Development Facilitation Team (DFT) – Review Comments

Project No: PR-2022-006841 **Date:** 05/10/2023 **Agenda Item:** #5 Zone Atlas Page: J-15

Location: [1801 MESA VISTA DR NE between BUENA VISTA ST NE and YALE BLVD NE]

Application For: SD-2023-00090- PRELIMINARY/FINAL PLAT (DHO)

**Plat for  
Lot 1-A, Block 3  
Sigma Chi  
Being Comprised of  
Lots 1, 2 and 5, Block 3  
Sigma Chi  
City of Albuquerque  
Bernalillo County, New Mexico  
April 2023**

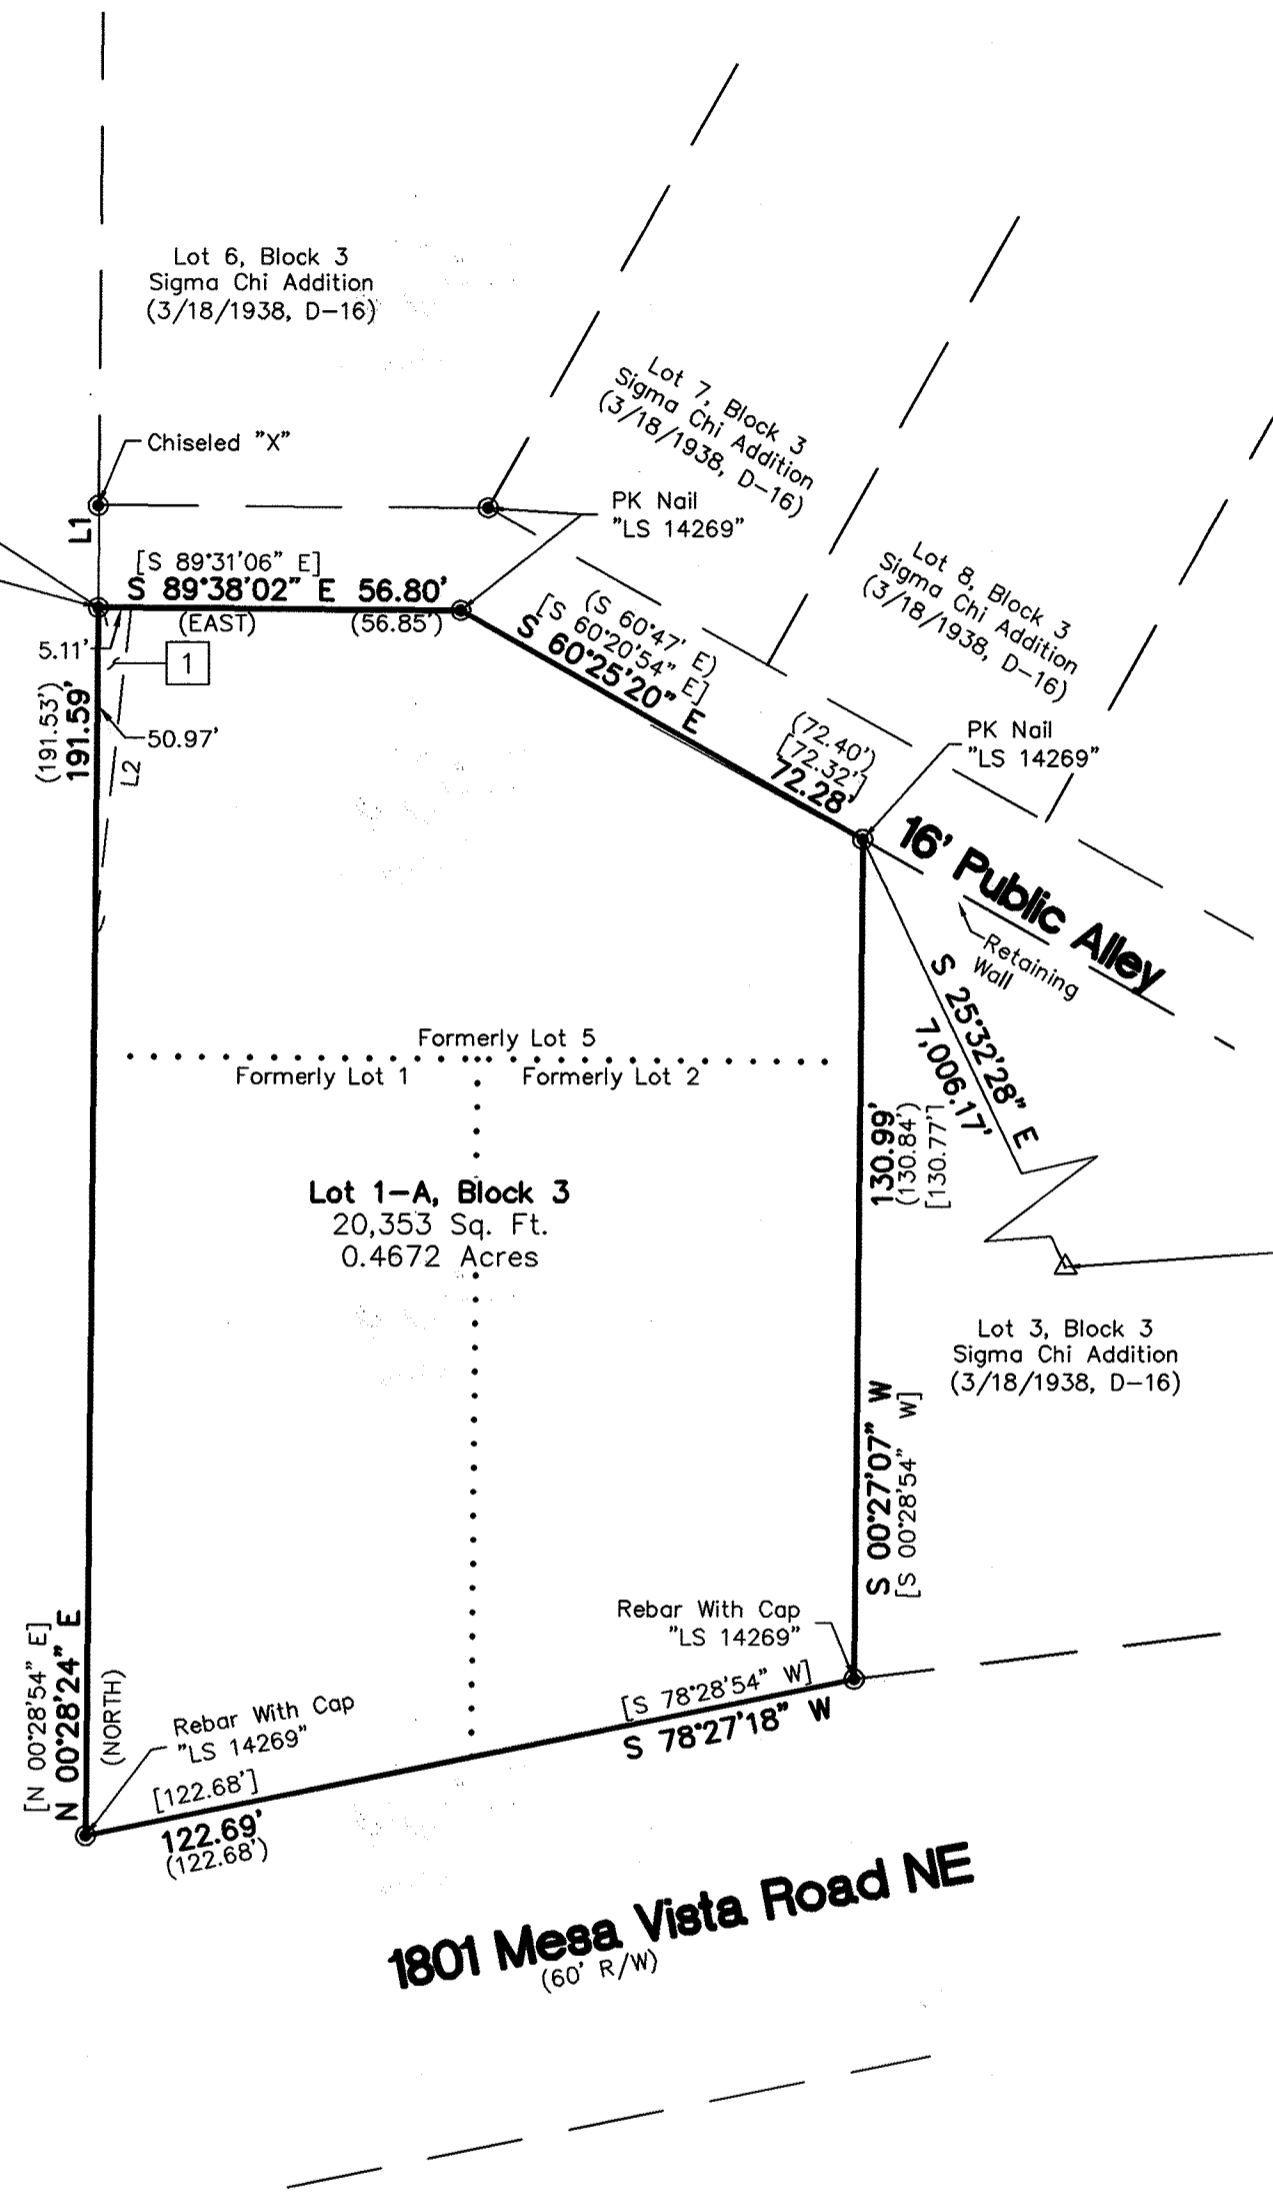
1. Justification for the alley to remain 16' is acceptable.
2. Curves are required at intersection property corners both at Mesa Vista/Buena Vista and public alleyway/Buena Vista unless you can show that the property corners are outside of the clear sight triangle. Consider location of public infrastructure and sight distances when determining radii. Keep private infrastructure outside of public right-of-way.
3. For future development, a TCL (Traffic Circulation Layout) will be required before site plan or building permit. Fill out Traffic Scoping Form to determine any potential Traffic Impact Study requirements for future development.
